ITEM 1.7 (a)

Issue/ Objection:
Common Circulation and Spaces

85 Harrington Street
The Rocks
GOLDEN AGE & HANNAS THE ROCKS

RESPONSE TO DoPE
ITEM 1.7 (a)

2 PLAN Level 5 Indicative Plan showing Plenum
1:50

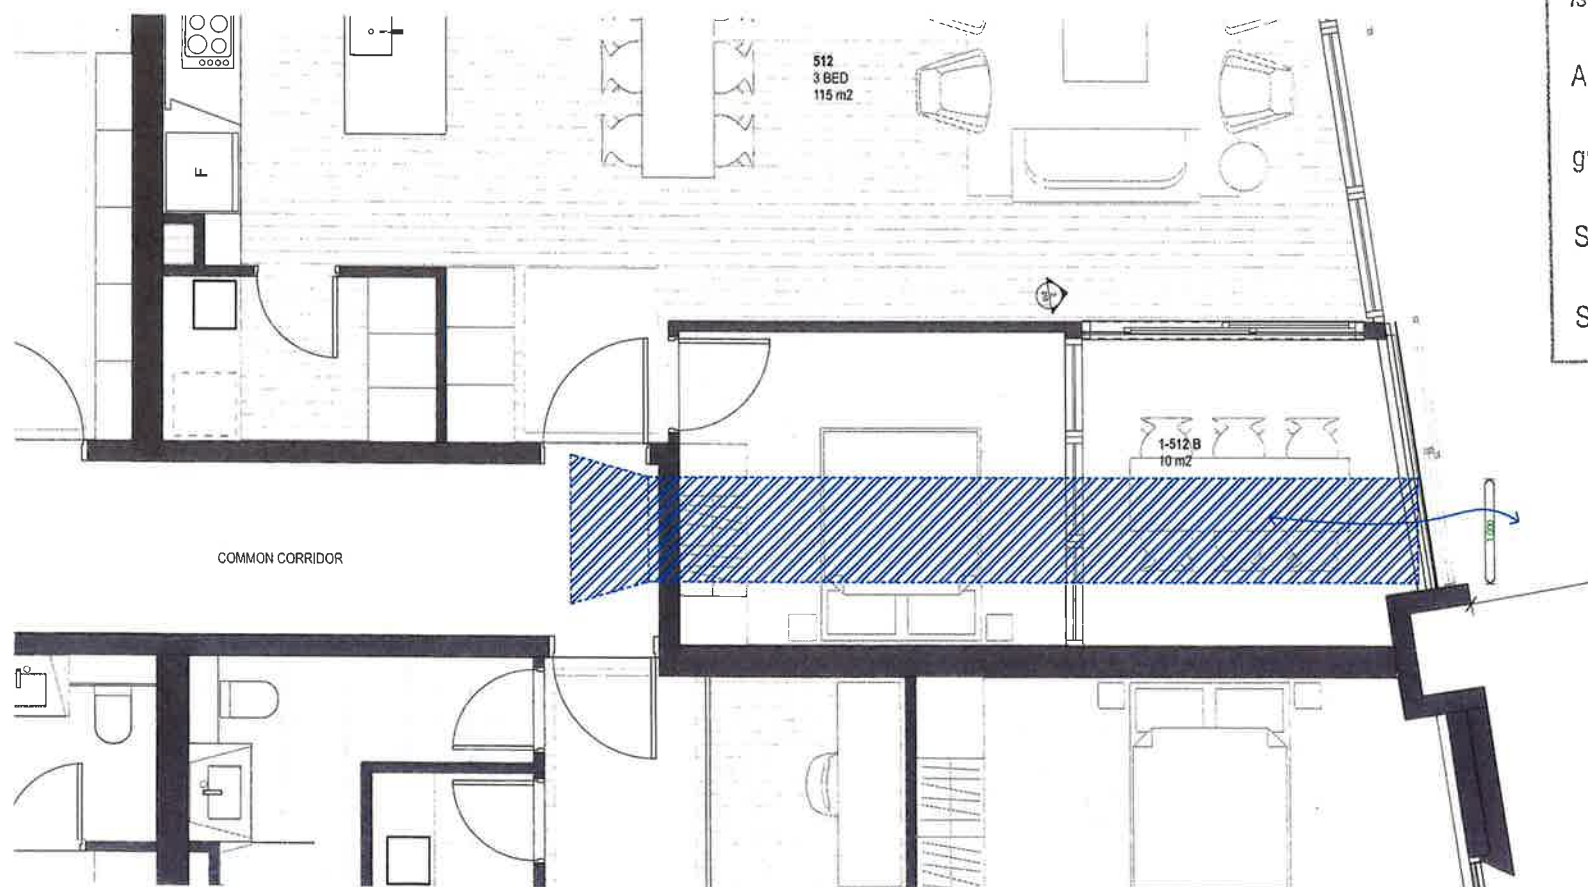
Description:
Given 12 units are proposed off the circulation core within Building 1 (exceeding the design criteria recommended maximum of eight), the Department requests the design of the proposed common corridors, particularly on levels two to five, be revised to improve amenity through increased levels of daylight, natural ventilation and outlook.

Response
The No. of apartments off a corridor on Level 2-3 is 5: < than the maximum of 8. The primary entrance for apartments 306 to 312 (Bldg1) is off Gloucester Street where residents and visitors enter the apartment. The door fronting the corridor is used only for access to the basement and garbage rooms. The proposed introduction of a plenum on the northern end of the corridor will further increase amenity of the space via promoting cross ventilation. **Complies? Yes**
